TfNSW Reference: WST23/00092/01 SF2023/131539

Your reference: SSD-8911

SSD-8911: Review of Environmental Impact Statement – Sundown Solar Farm

Figure 1. Gwydir Highway / Spring Hill Mountain intersection upgrade

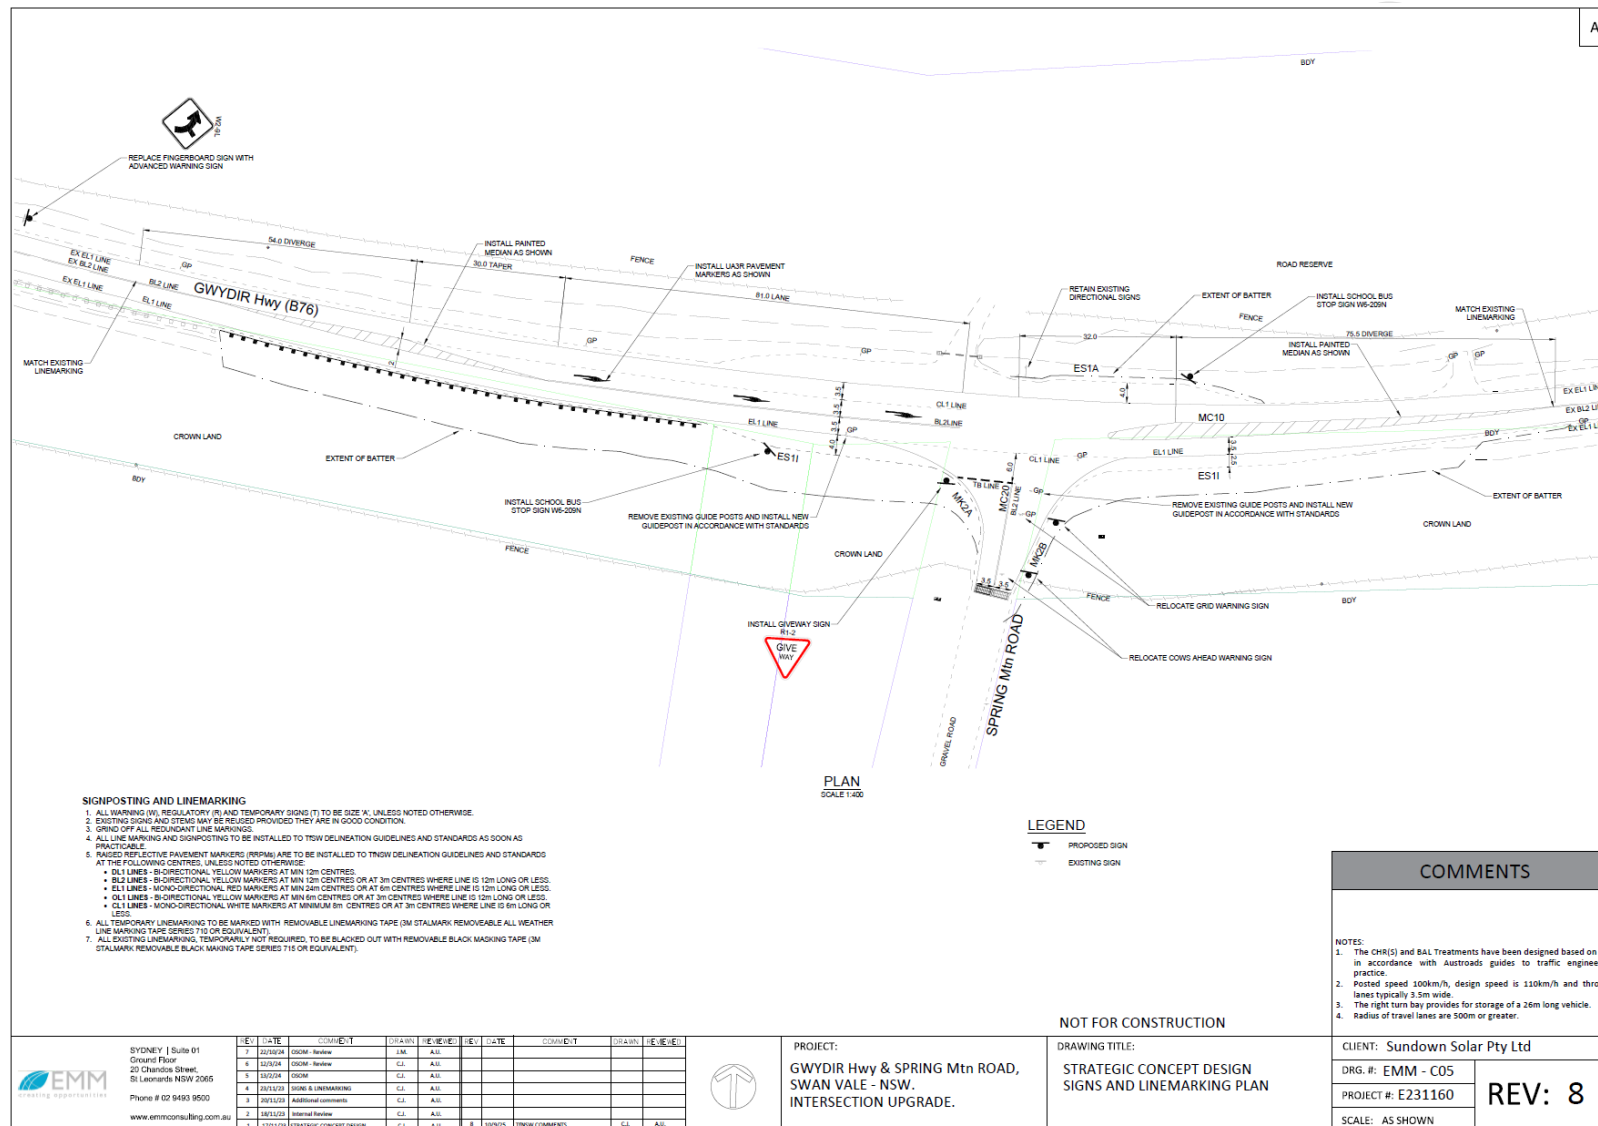
6. Table 4.3 of the TIA suggests the property access opposite Spring Mountain Road has been closed and moved approx. 50m to the west, Google Maps still shows the access opposite Spring Mountain Road. Evidence of the relocation and closure is required, any existing property access within the intersection upgrade footprint needs to be shown within the design.

7. Spring Mountain Road is unsealed at the intersection with Gwydir Highway which provides a safety risk, this must be sealed a minimum of 10m back from the edge of seal to prevent loose gravel tracking onto the highway. The plans need to be updated to demonstrate this.

8. There is an existing school bus stop located at the Gwydir Highway/Spring Mountain Road intersection (with no signage or infrastructure). The proposed bus stop facilities need to be shown within the plans considering safety and further information detailing the proposed measures to prevent conflict with vehicles travelling through the intersection is needed.

9. The fingerboard sign on the eastbound approach to the intersection on the Gwydir Highway should be replaced by an Advance Intersection Warning Sign, the plans need to be updated to demonstrate this.

10. Appendix B includes a 2D layout over an aerial image. A strategic design is required which must be to scale and include, but not be limited to details on, legal property boundaries including the existing road reserve boundaries, existing and proposed ground levels, existing and proposed lane configurations, existing and proposed lane widths, new lane lengths, typical cross sections, conceptual drainage details (for any changes required), proposed signage, impacts to utilities &/or signage etc.
